Please upload the attached as an amended plan for A/146/19/PL.

Please find attached an amended drawing containing the changes that you have requested – (1) removing the rear projection so that the entire garden depth is 8.5m, (2) removing the rear dormer window to Bedroom 1 replaced with 2no. roof-lights at 1.5m height in order to ensure no possibility of overlooking, and (3) and very modestly enlarging the front elevation in line with your comment.

Rev	Date	Revision Details	Dr	Ch
P4	17.12.19	Amendments following planner comment.	JT	AK
P3	25.10.19	Revised notation.	JT	AK
P2	25.10.19	Revised red line and road name correction.	JT	AK
P1	17.10.19	Planning Issue.	JT	AK

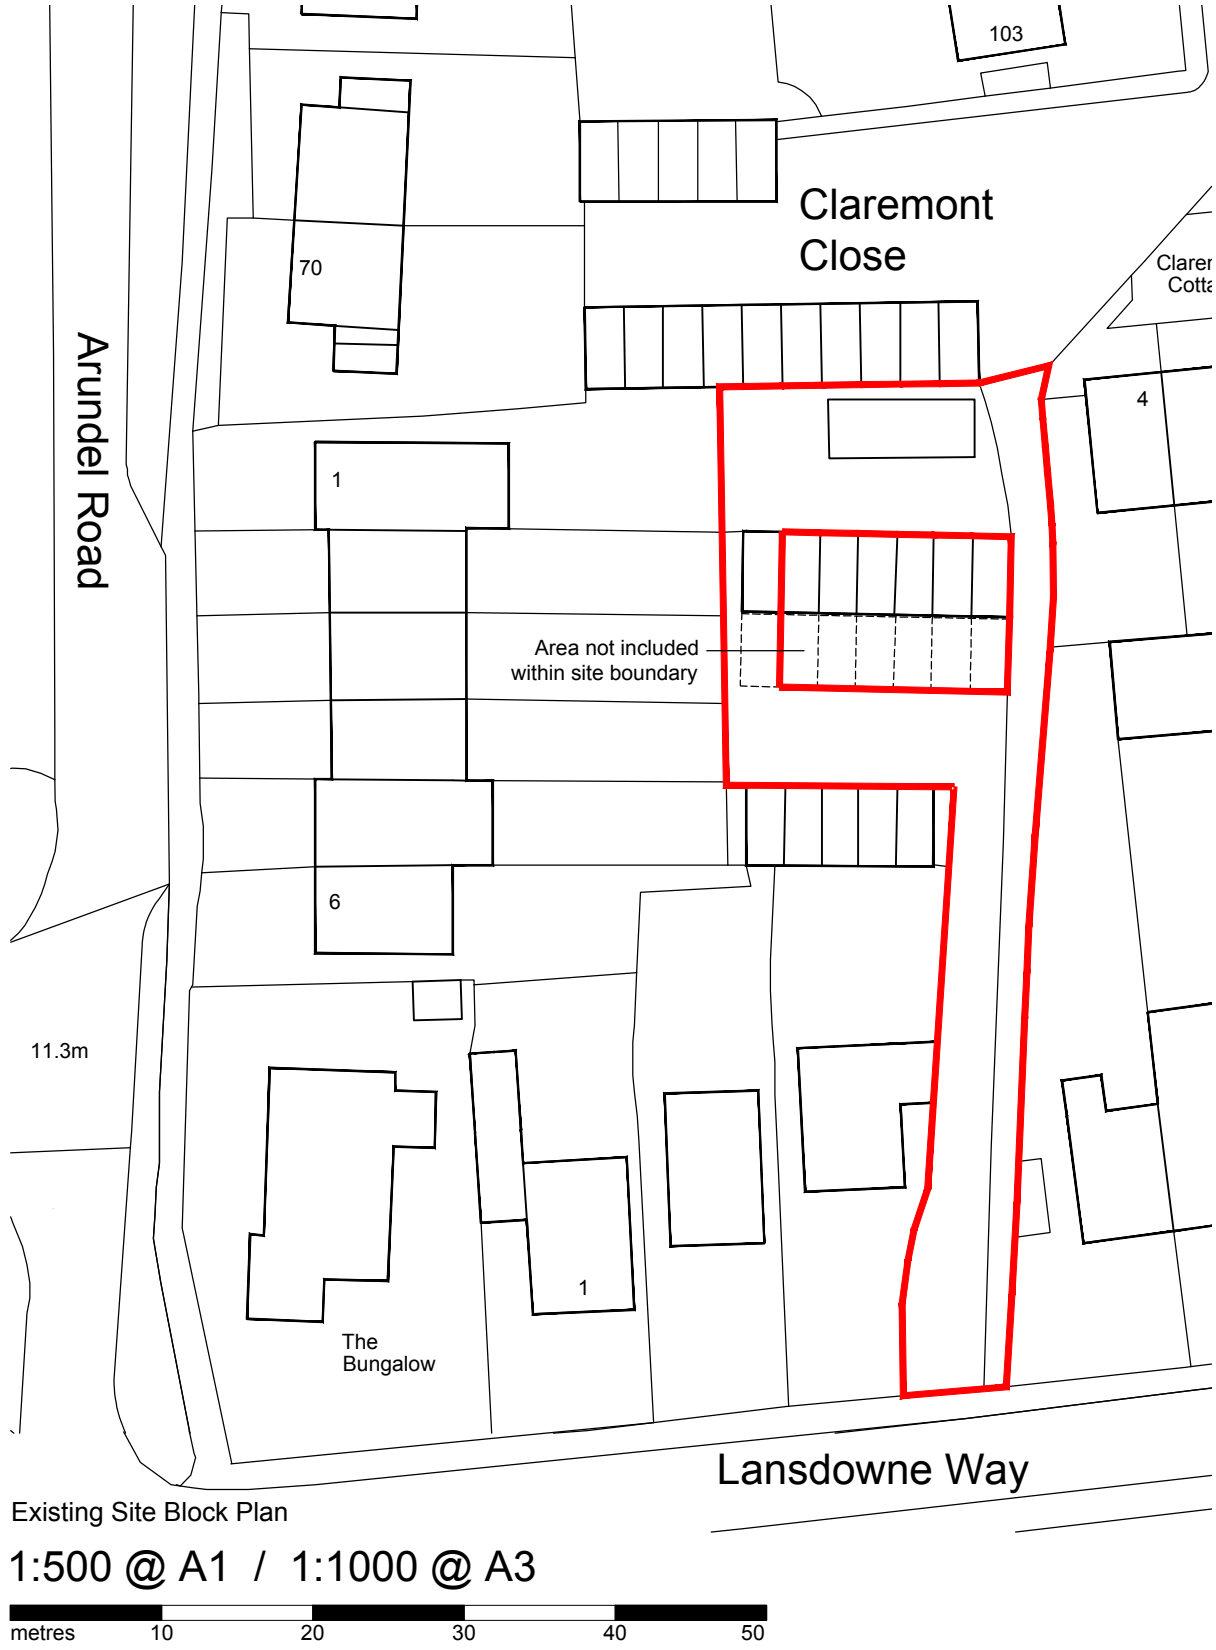
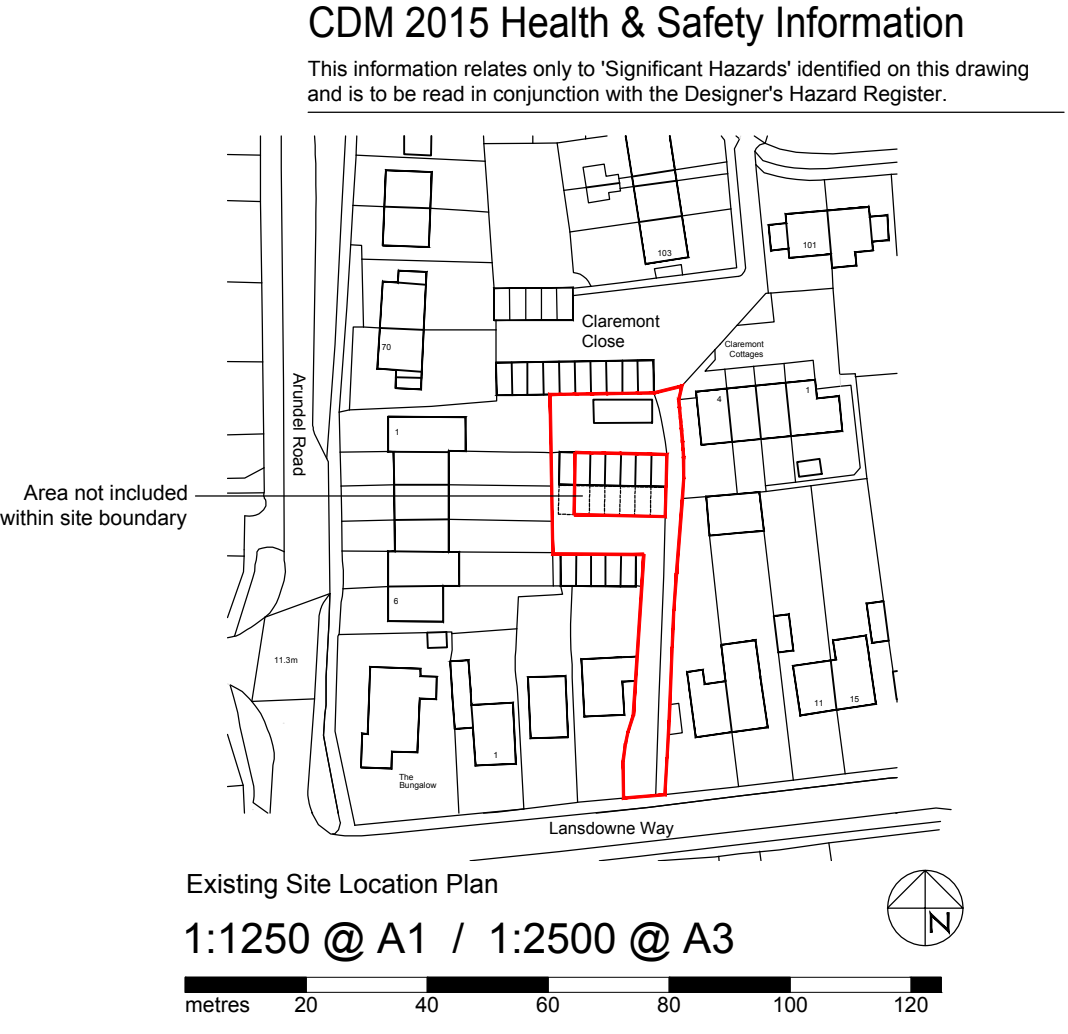
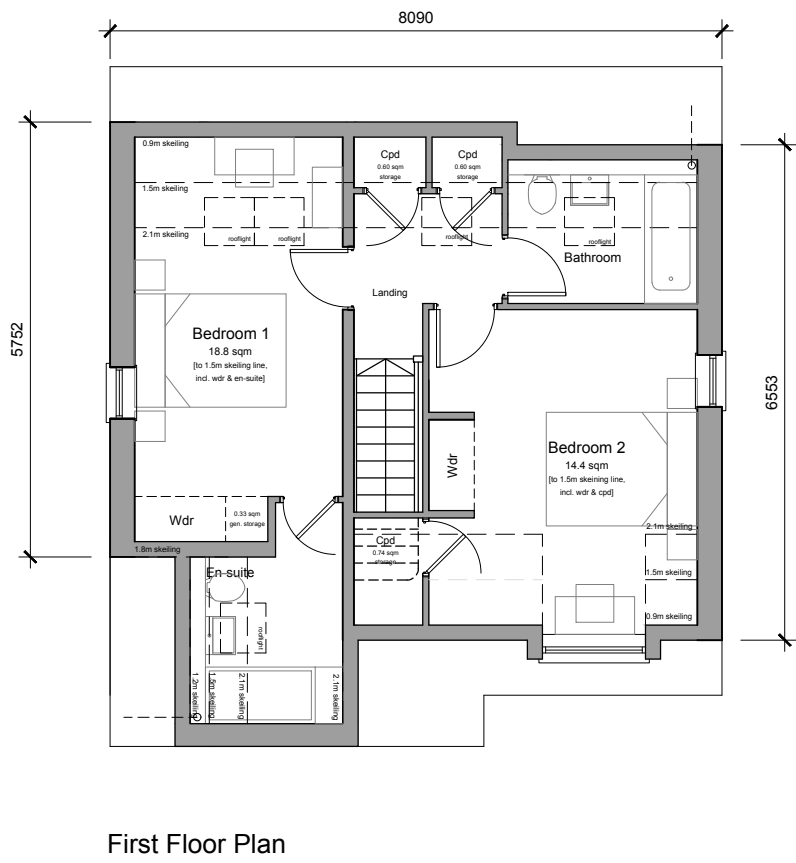
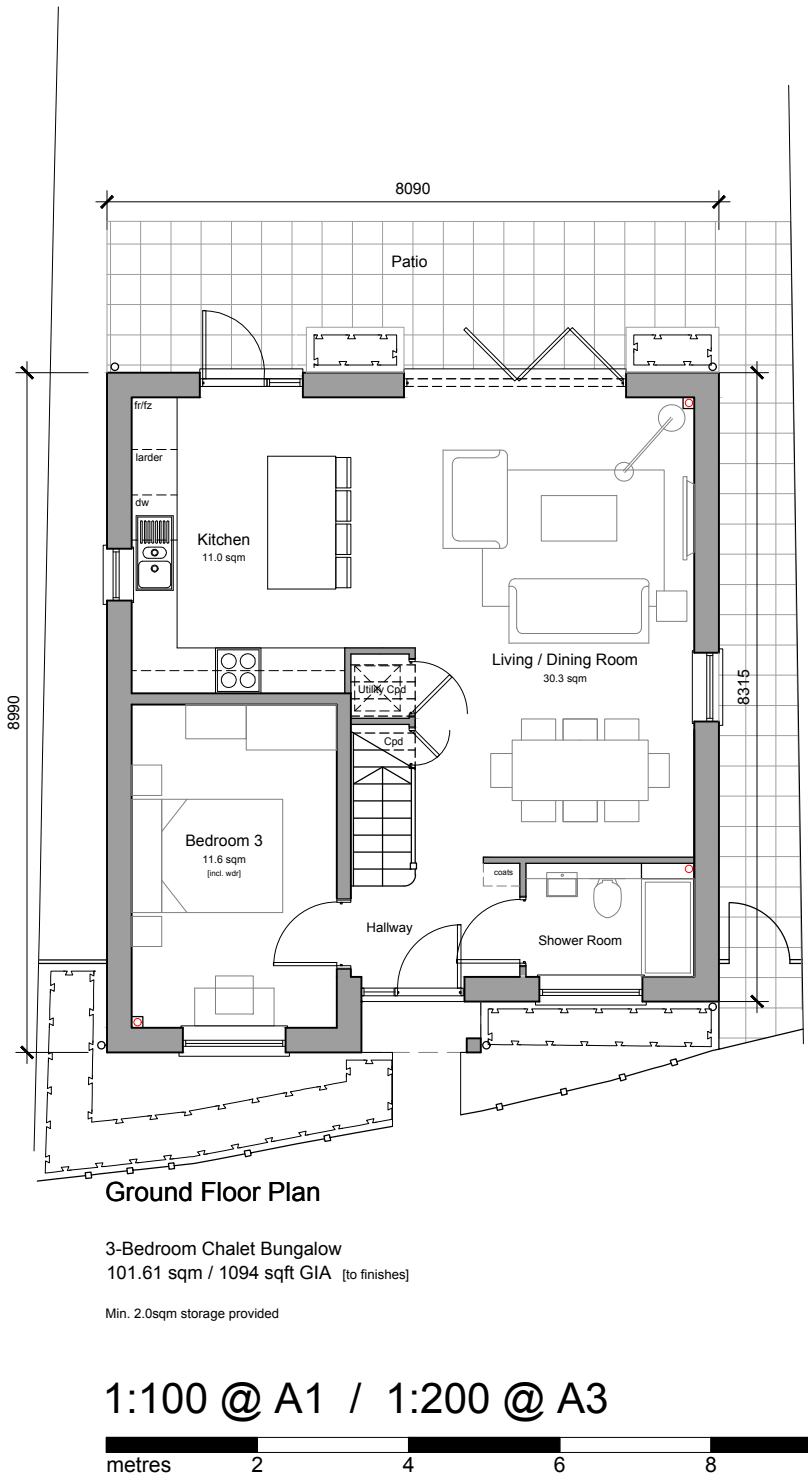
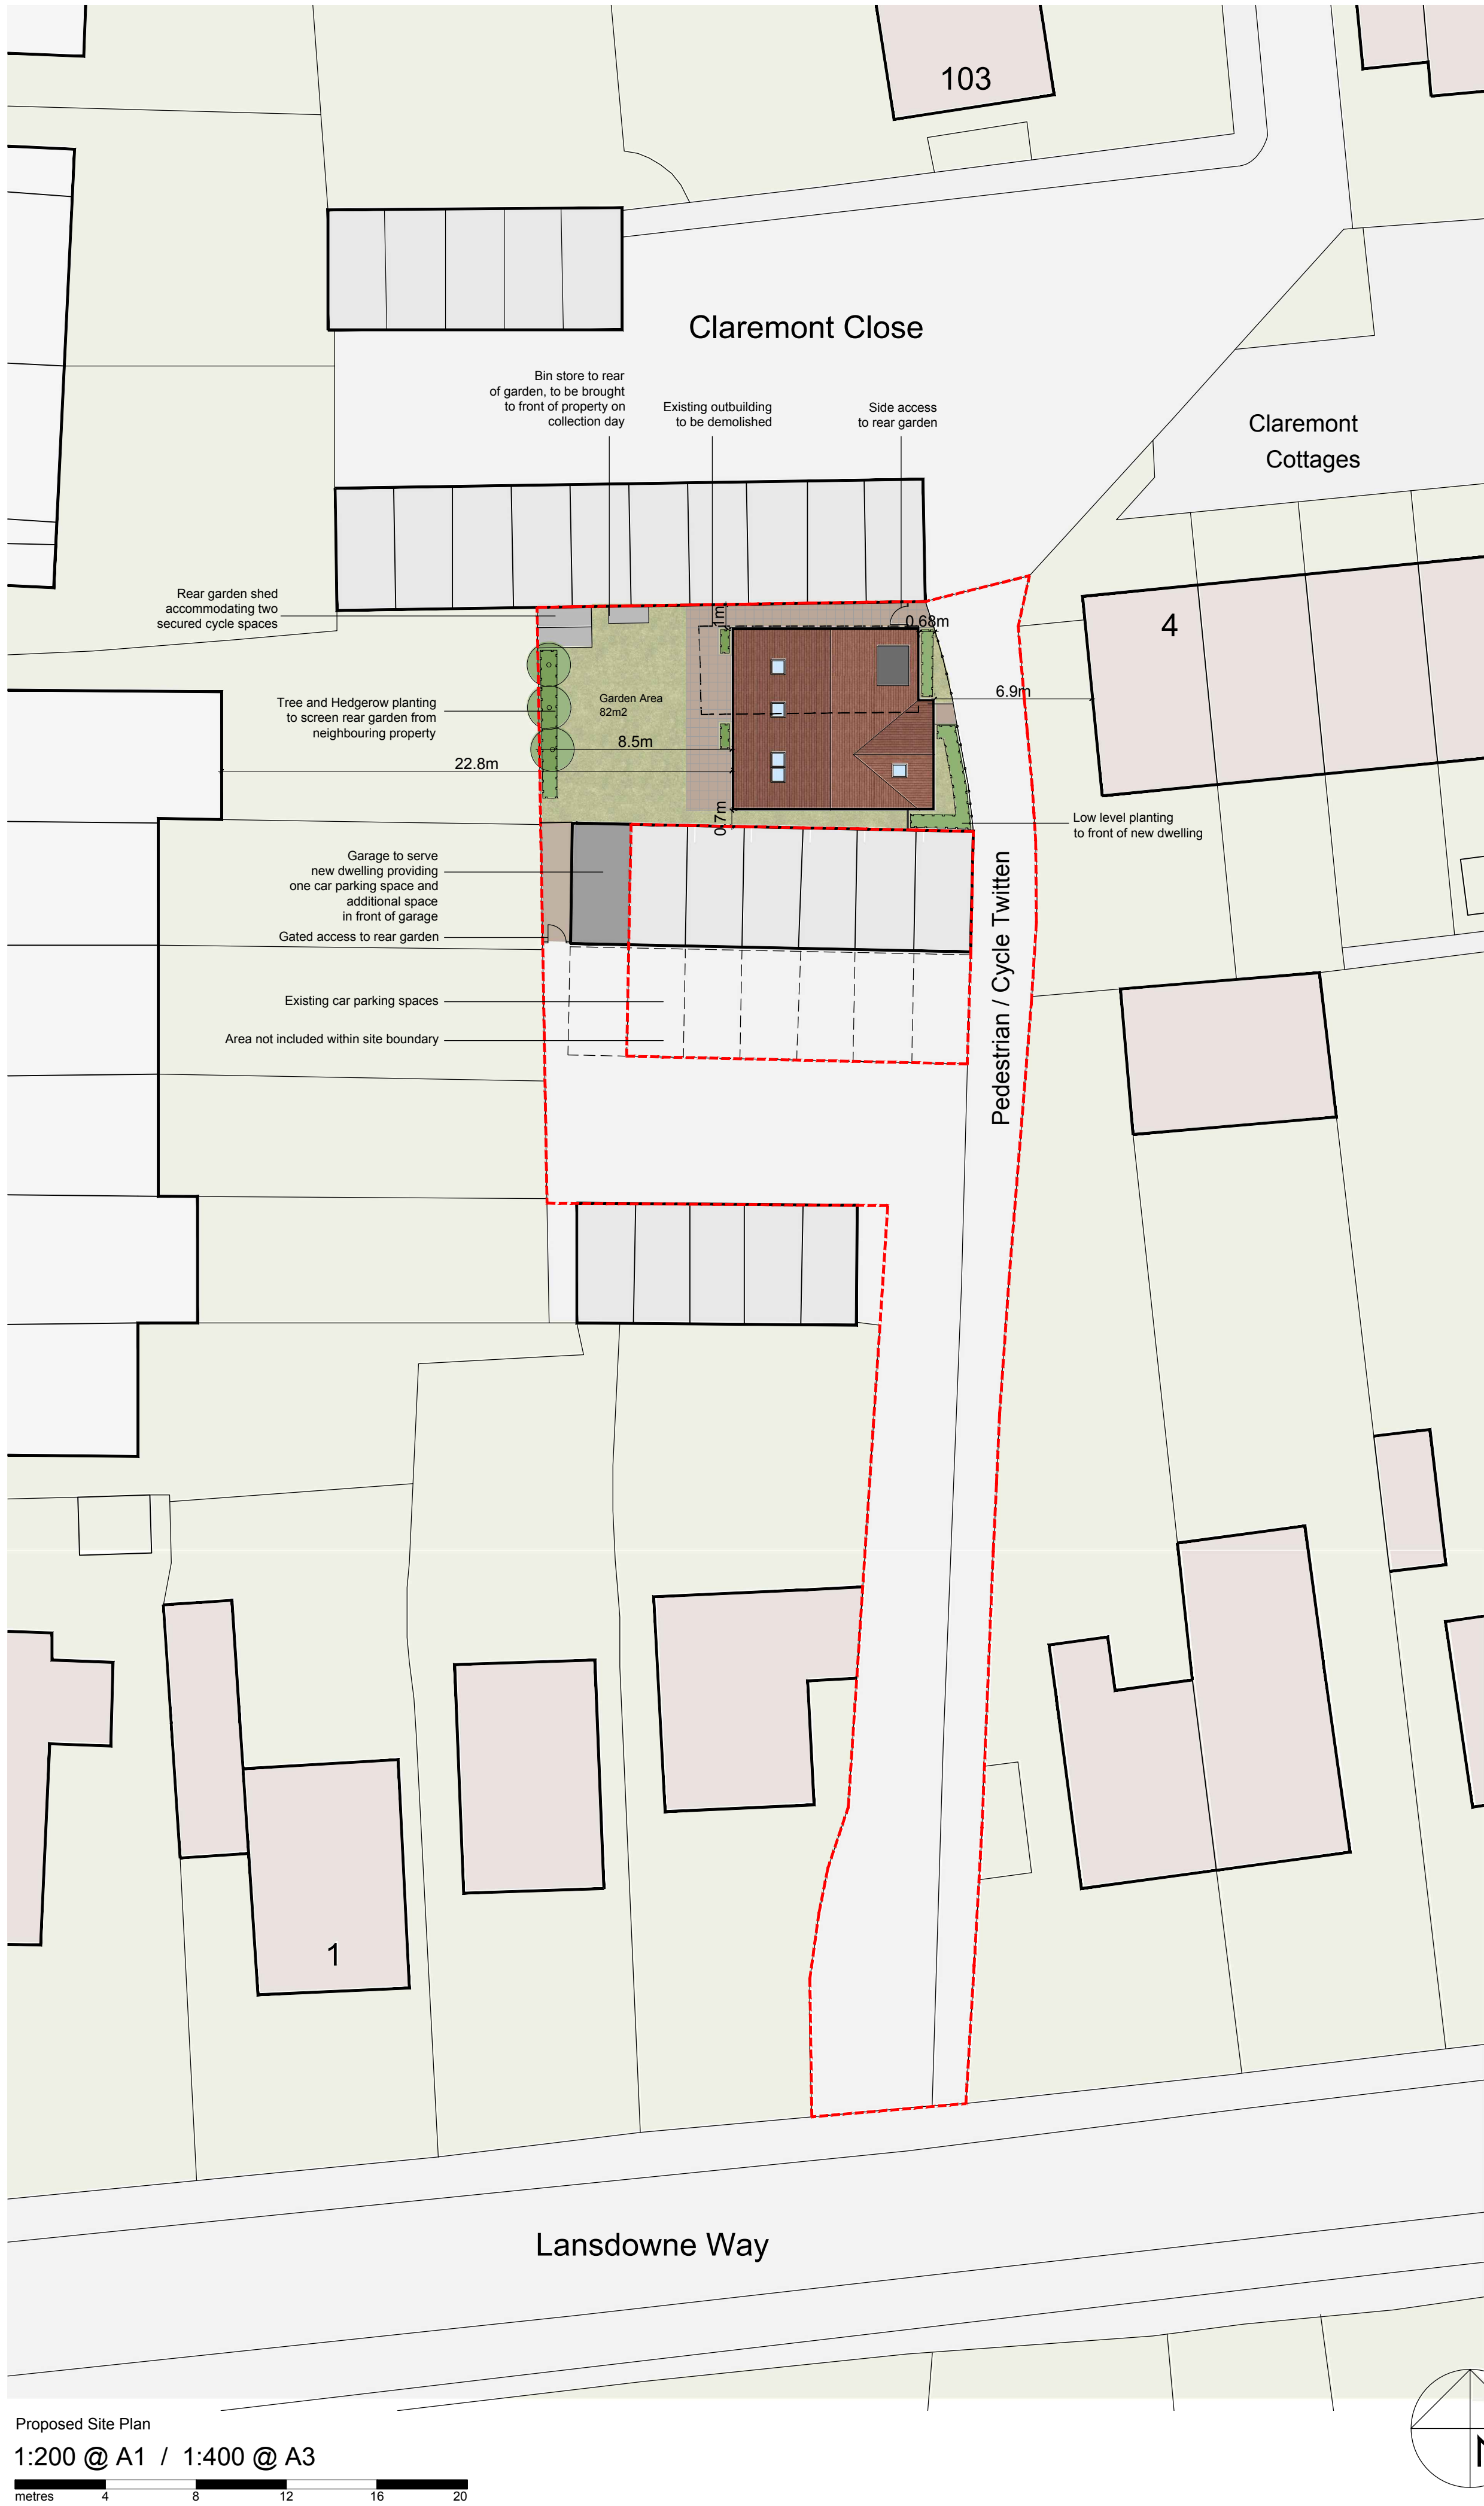
I had a chat here internally and we feel the proposal could be ok, on balance once a few changes are made. I mentioned your willingness to make whatever changes we felt necessary to get it over the line. Could you send in an amended plan removing the rear dormer (replacing it with a rooflight) and squaring off the rear elevation so that the rear garden depth would now be 8.5? If you wish you could slightly enlarge the dwelling at the front elevation to get back some internal space.
